## Department of Transportation

Traffic & Safety - Permits Unit

RE: Rock Creek Mesa Development Plan (DEPN-25-0173)

HIGHWAY 115 IMPROVEMENT PLAN

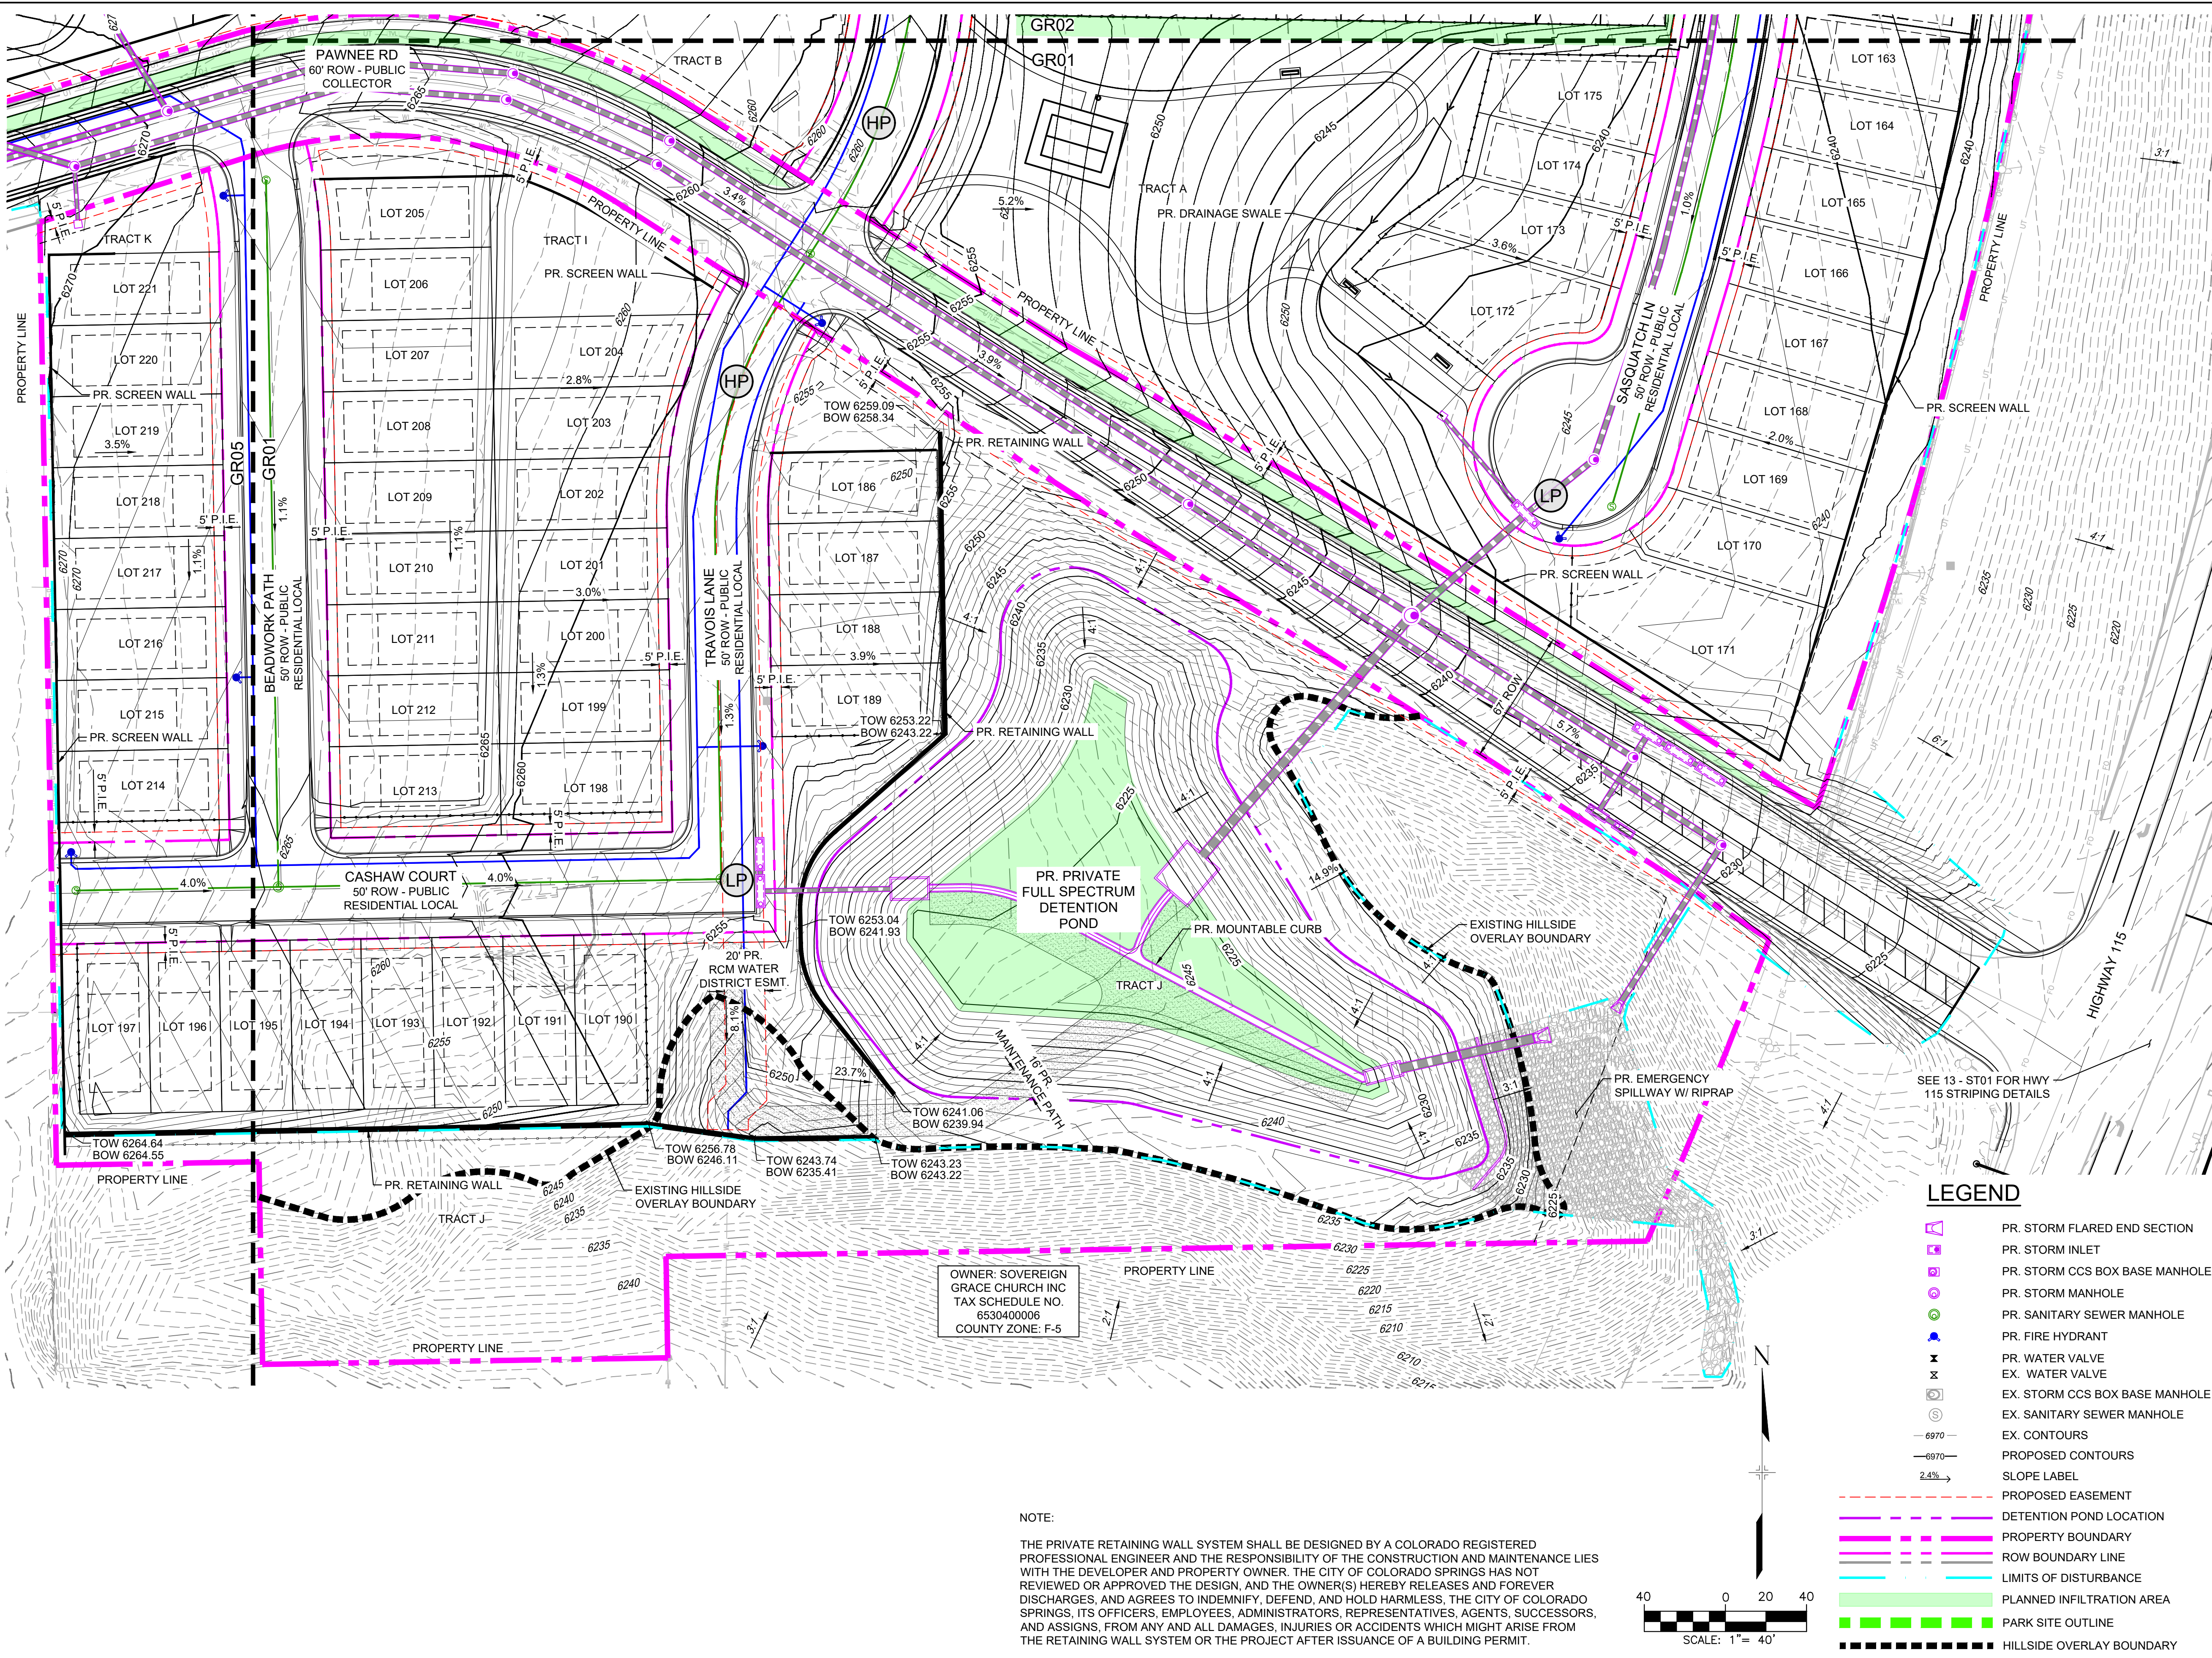
- The following roadway improvements at Pawnee Rd and SH15 are required:
  - Extension of the northbound left turn lane to a total length of 1,025-ft(700-ft of deceleration, 25-ft of storage, and 300-ft of taper).
  - Construction of a 4-ft wide raised median converting Cherokee Rd & SH115 to right in/right out only access.
  - Construction of a 190-ft eastbound left turn lane (100-ft of storage and 90-ft of taper).
  - Extension of the southbound right turn lane to 1,000-ft(700-ft of deceleration and 300-ft of taper).
- This intersection will warrant signalization of SH115 and Pawnee Road in the short term. The applicant is responsible to design & construct the above improvements plus the traffic signal at time of permitting and notice to proceed.
